REFUSAL OF PLANNING PERMISSION

APPLICATION NO. 2016/0682

Proposal Conversion of existing garage to bungalow
At 102 Sackville Street, Barnsley, S70 2BX

PLAN & ELEVATIONS

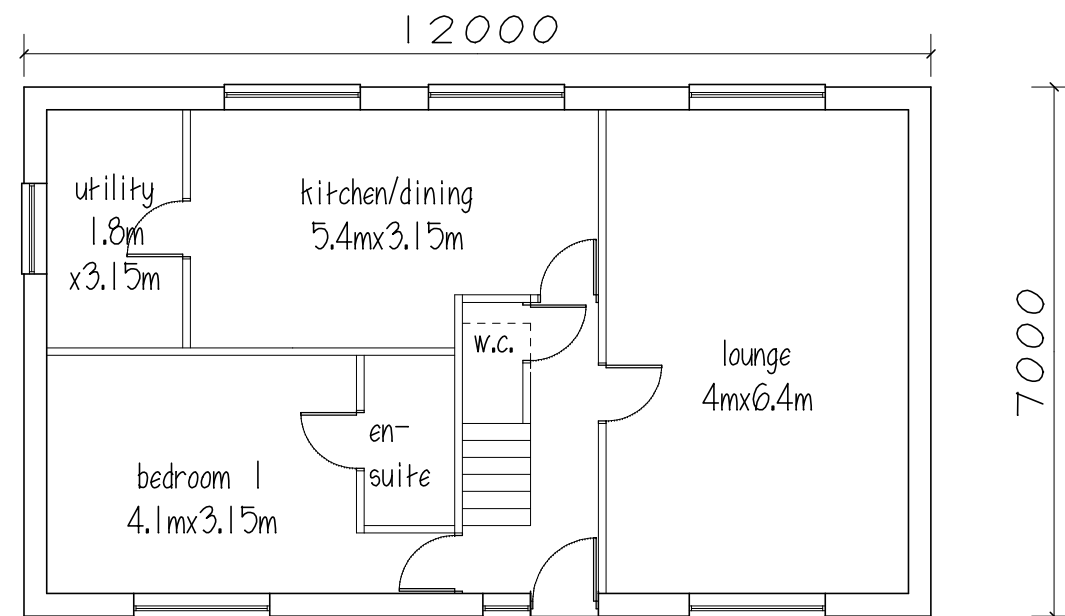
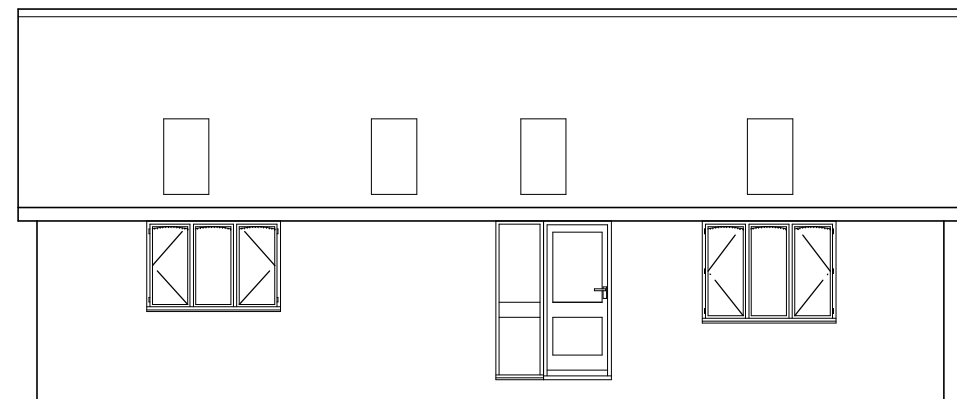
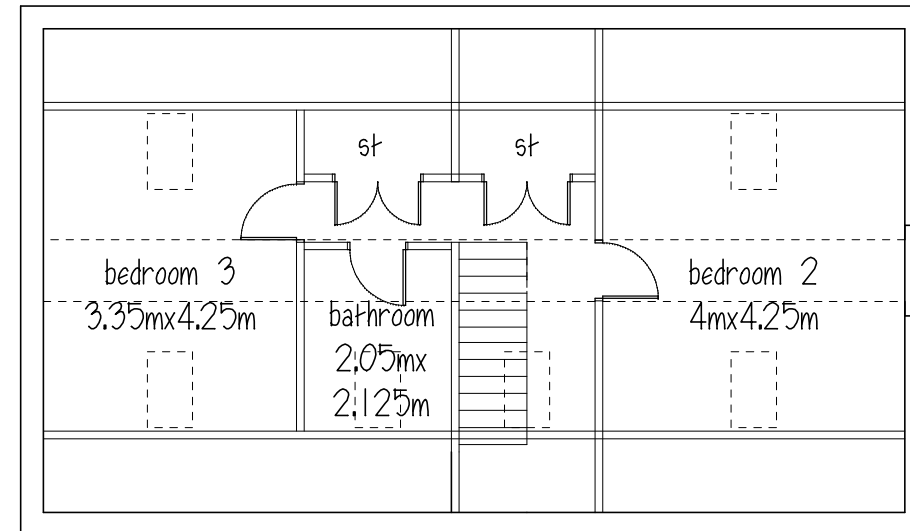
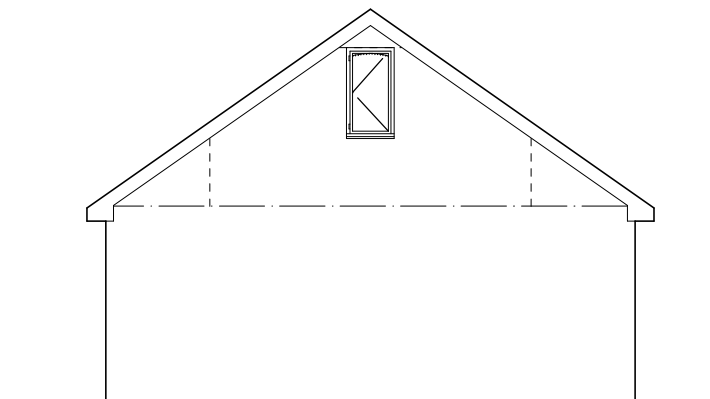
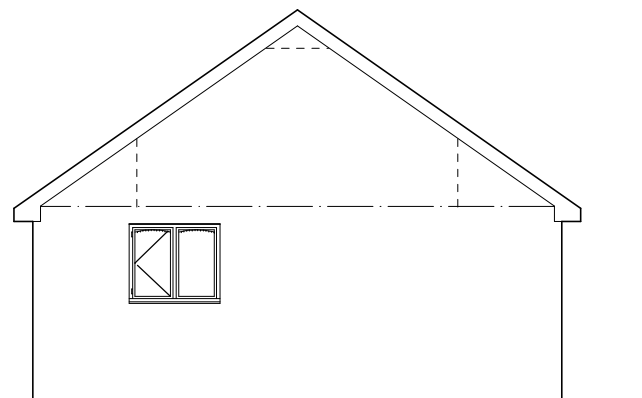
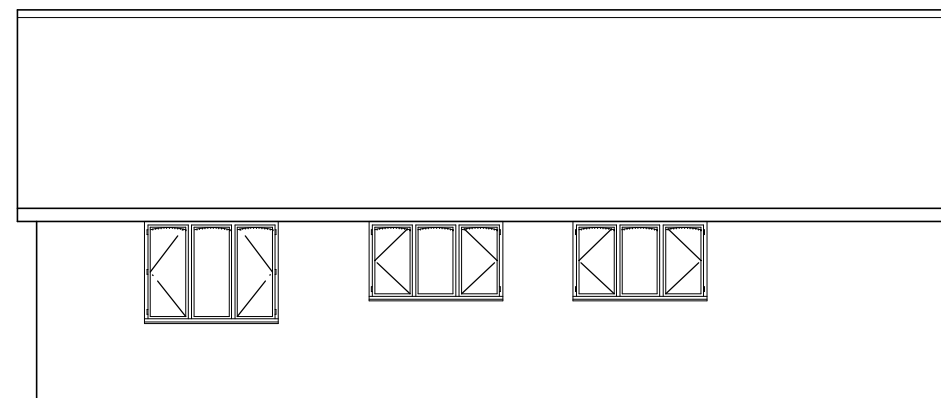
- 1 In the opinion of the Local Planning Authority the proposed conversion would be contrary to Policy H8A & H8D of the Unitary Development Plan, Policies CSP 29 & 30 of the Core Strategy and the Council's Supplementary Planning Document 'Designing New Housing Development' in that it would result in tandem/backland development which would be inconsistent with the character, layout and development pattern of the area to the detriment of visual amenity.

- 2 In the opinion of the Local Planning Authority, the proposed conversion would be materially detrimental to the amenities of the occupants of the neighbouring dwellings, namely number 12 Loxdale Gardens by reason of the location and proximity of habitable room windows in relation to neighbouring habitable room windows and private amenity spaces. Furthermore, the proposal would introduce noise and disturbance into an area of garden that neighbouring occupants could reasonably expect to remain quiet and undeveloped. As such, the proposal would be contrary to Unitary Development Plan Policies H8A & H8D and the Council's Supplementary Planning Document 'Designing New Housing Development'.

- 3 The proposed development fails to provide sufficient and suitable car parking provision within the site, as recommended by Supplementary Planning Document 'Parking'. Furthermore, the proposed development would result in the intensification in use of a substandard access. Consequently, the proposal would be to the detriment of the safe and free flow of traffic on the highway and contrary to saved UDP Policy H8D and Core Strategy Policy CSP 26.
